Re: Glads Holding – 4911 Chappell NE, Engineer's Stamp dated 3-22-07
Tracts 9C of the Renaissance Center, (F16/D52)

Re: Glads Holding – 4911 Chappell NE, Engineer's Stamp dated 2-22-07
Tracts 9C of the Renaissance Center, (F16/D52)

RE: Glads Holdings Office Building (F16/D52)

Re: Glads Holding – 4911 Chappell NE, Engineer's Stamp dated 1-24-07
Tracts 9C of the Renaissance Center, (F16/D52)

GRADING AND DRAINAGE PLAN

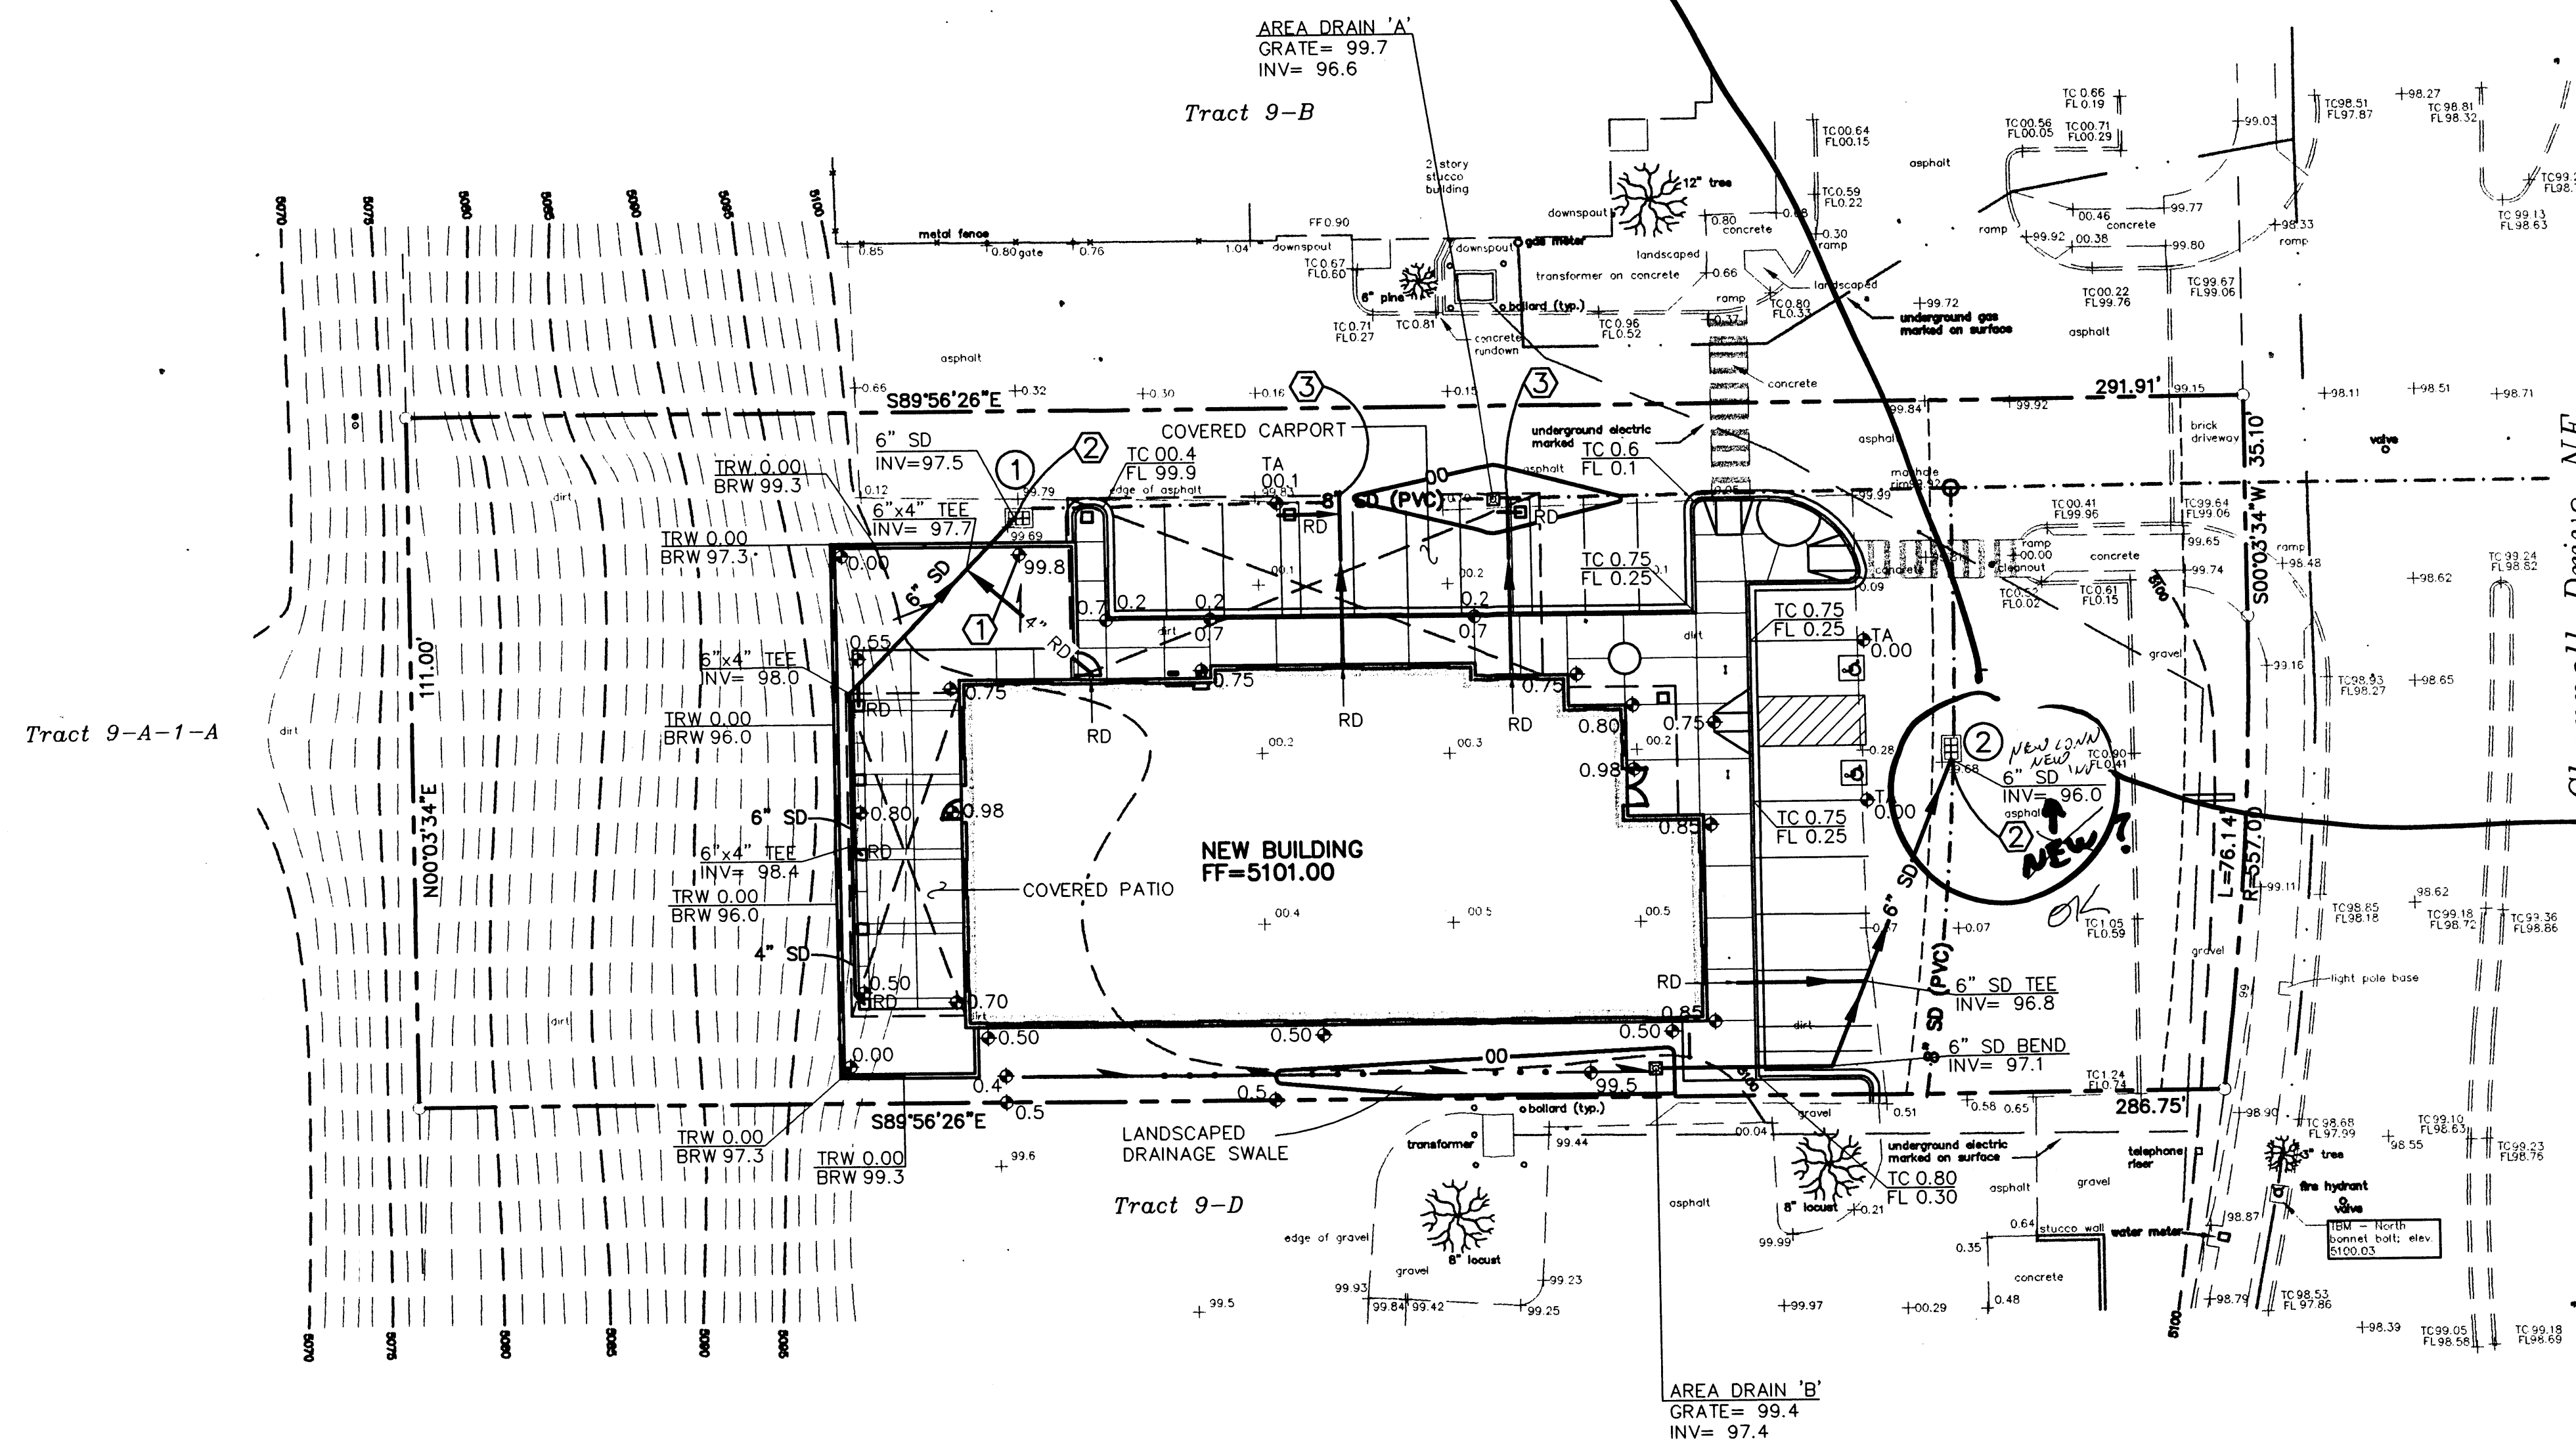
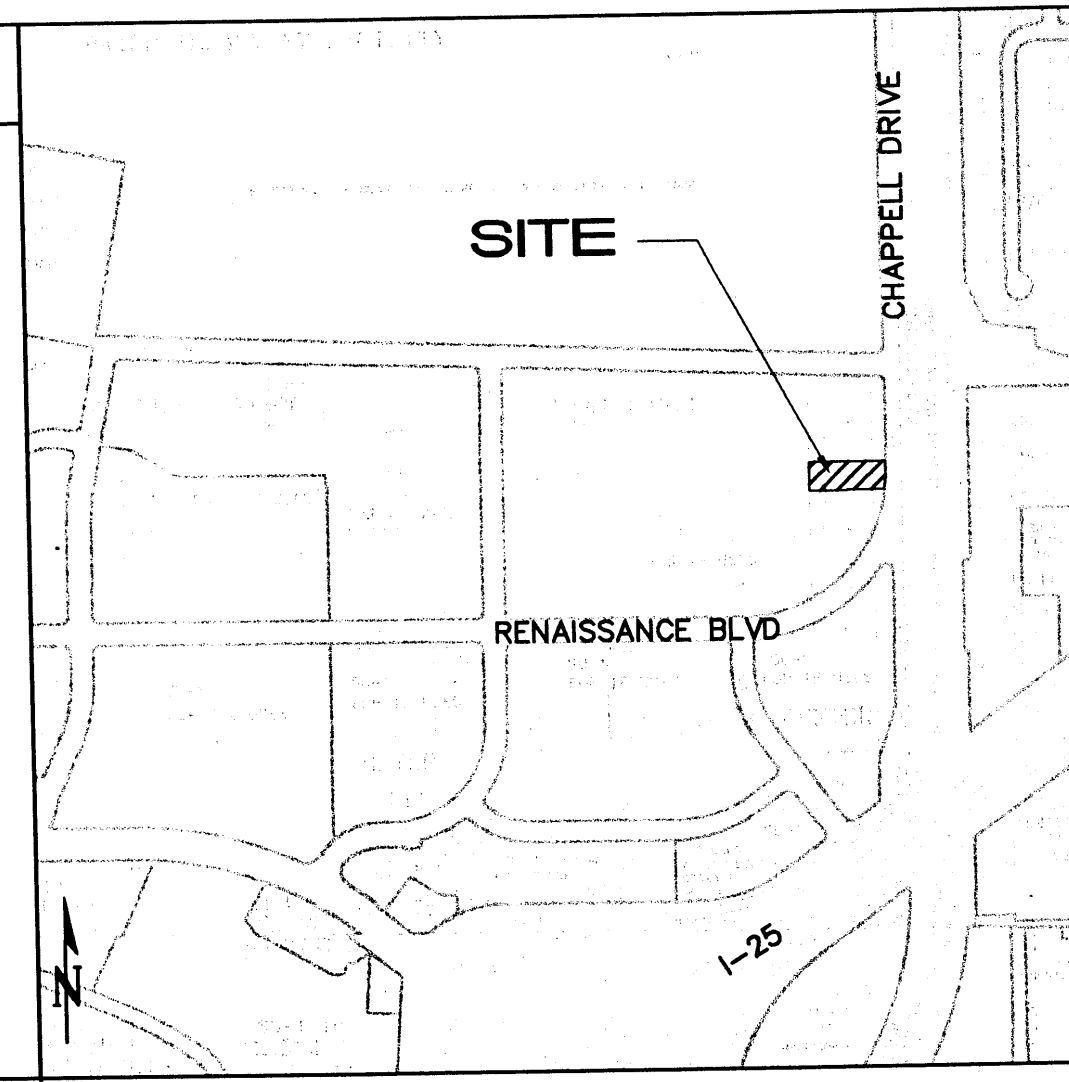
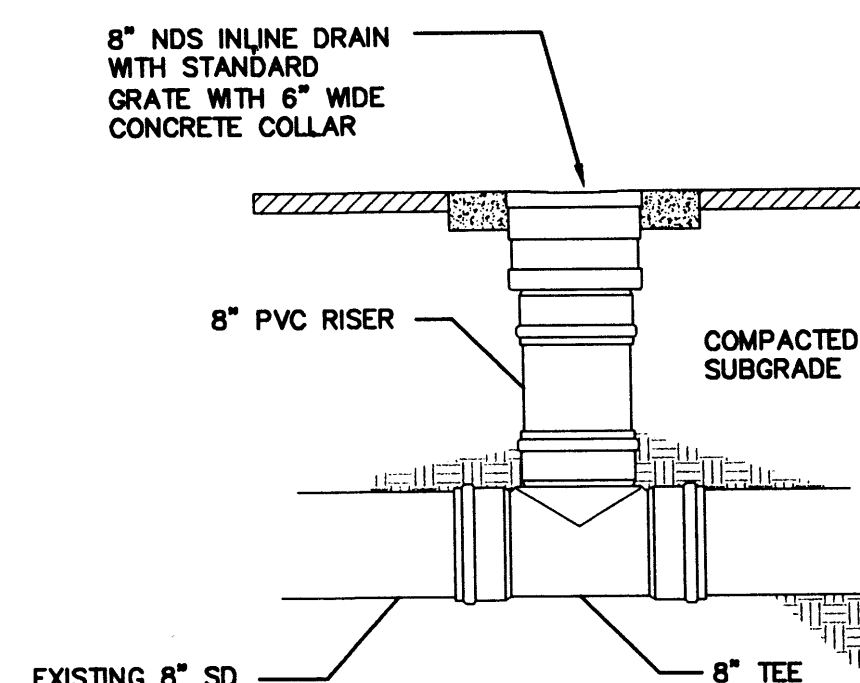
- Please reference and / or include the appropriate FIRM map and state whether the site is or is not located in a flood plain.
- Please provide a detail for the proposed retaining wall(s).
- The tabular invert elevation for drain 2 conflicts with the notes on the plan.
- Please revise the proposed conditions to indicate that the on-site storm drain system is a privately owned and maintained facility. Also show the easement through which the storm drain is routed.
- Please provide a detail for the on-site curb and gutter and / or reference the appropriate standard drawing(s).
- Will the storm drain inlets be 'type D' or will a different configuration be used? Please specify for both the inlets and area drains.

- 1) FIRM floodplain information has been added.
- 2) Though I don't agree that structural detail review is within your purview, a detail has been provided.
- 3) The table indicates the existing inlet invert. The plan note indicates the new 6" storm drain invert.
- 4) The text now reflects the onsite storm drain as 'private' and as such no easement is necessary.
- 5) See comment 2 above regarding onsite curb detail which is provided.
- 6) Inlet details have been added.

4 DETAIL - TYPICAL STANDARD CURB & GUTTER
SCALE: 3/4" = 1'-0"

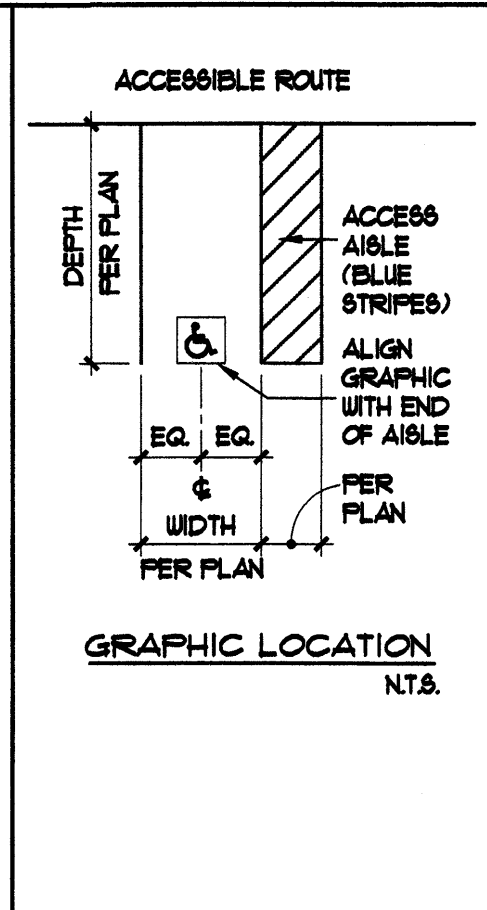
- Your curb detail indicates a modified 8-inch curb with a level gutter pan but the flow line and top of curb elevations on the plan indicate a 6-inch curb. Please clarify.
- With your revised submittal, please include a legend entry to specifically define the two (2) north – south dashed line types (adjacent to the existing, 8-inch storm drain and parallel to the eastern lot line) used on the plan.
